Mr. David Easton.
Re. FG/115/17/PL.

Ref: Planning Application No. FG/115/17/PL
(re-submission of FG/196/15/OUT and FG/69/16/OUT)

*Current
Objection*

Site layout block plan

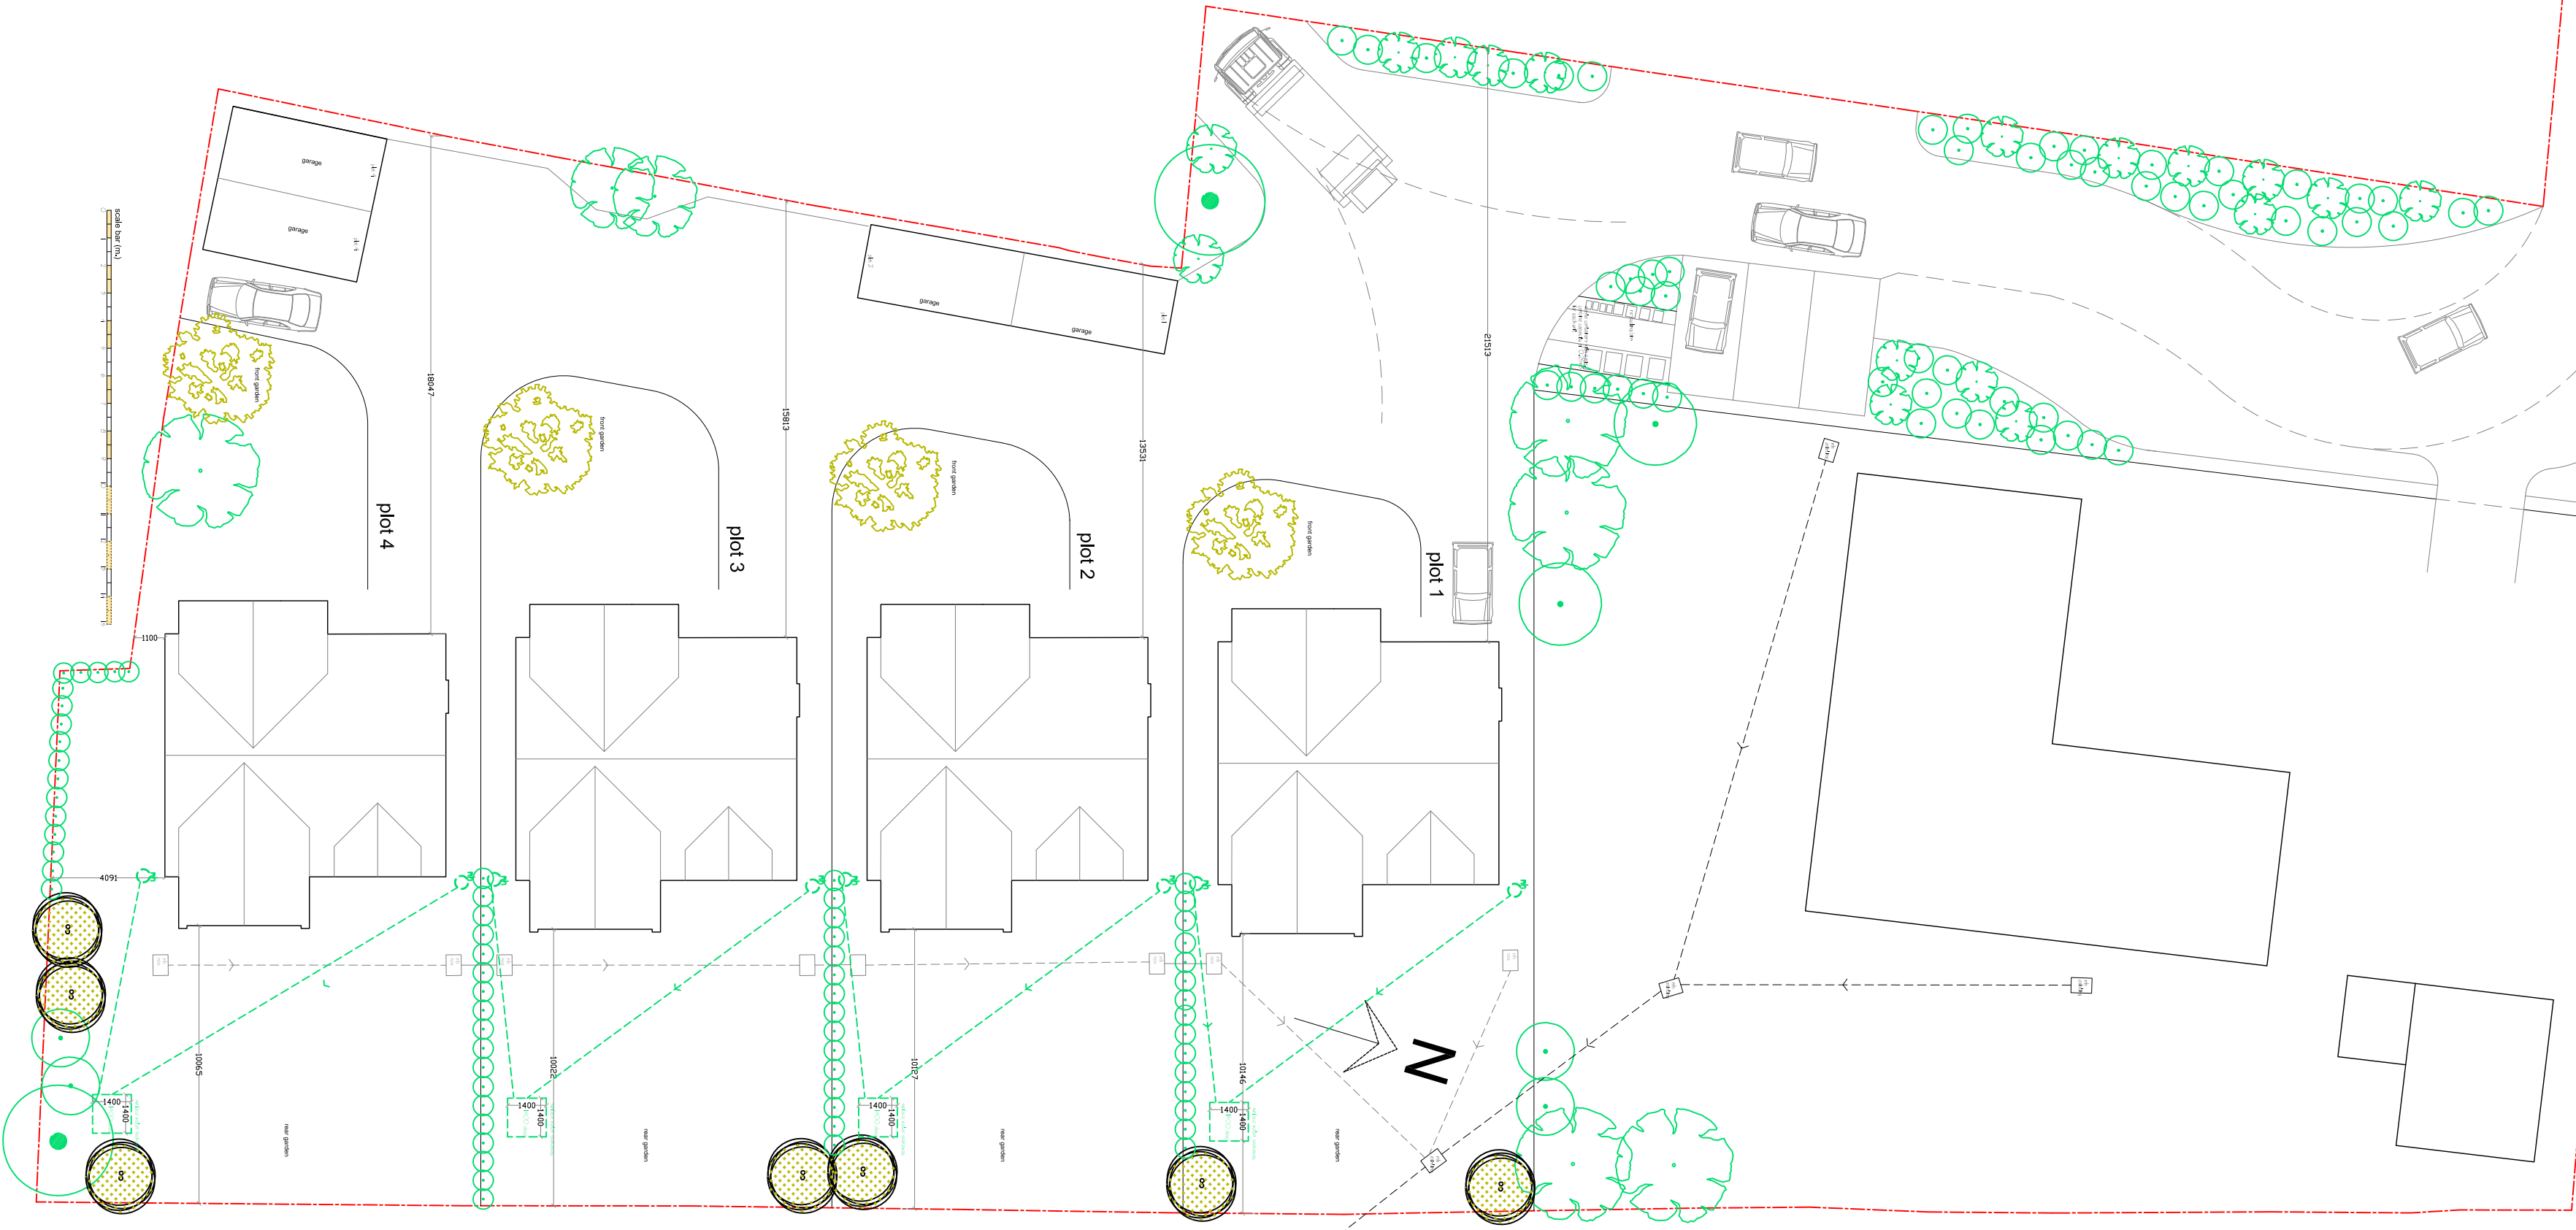
1. **Inadequate on site parking**

The designated parking is insufficient, the current occupants have 3 vehicles.

There is nothing to suggest each new house will have less, nor will there be any way of forcing residents to use their garages (as required by the Inspectorate conditions) solely for vehicle parking. The current provision is for 2 vehicles (one garaged and one on hard standing) for each dwelling. There is provision for only 3 visitor bays on the site.

3. **Traffic Light System**

Vehicles wishing to enter the site will be stationary in Ferringham Lane awaiting a green light (lights, that will be positioned somewhere within the entrance itself, that they may not even be able to see). If coming from the North, all vehicles, irrespective of size will be positioned on the wrong side of the carriageway in order to make the turn into the narrow entrance. Dependant on their size and length, may find they are unable to enter at all due to the width available and be forced to reverse in the middle of the highway. If the private traffic light system is not visible or is malfunctioning it will also cause vehicles to reverse back out into busy lane.

With three driveways of 46,44 and 42 in a line, there is no visibility splay available to the site that

can reasonably be maintained. Who would keep the "visibility splays unobstructed hereafter" as decreed by the Planning Inspectorate in their Condition 7 of the consent decision? Myself and all adjacent properties and those opposite will have future problems entering and leaving our properties if the development succeeds. (see photo below).

As the **only pedestrian access into and out of the site** the Inspectorate has specified a 4 metre shared surface access construction before any development takes place.

At present it is 3.63m which translates into the 12ft. strip of land that was originally part of my plot till 1954. Since then the boundary has stood as is.
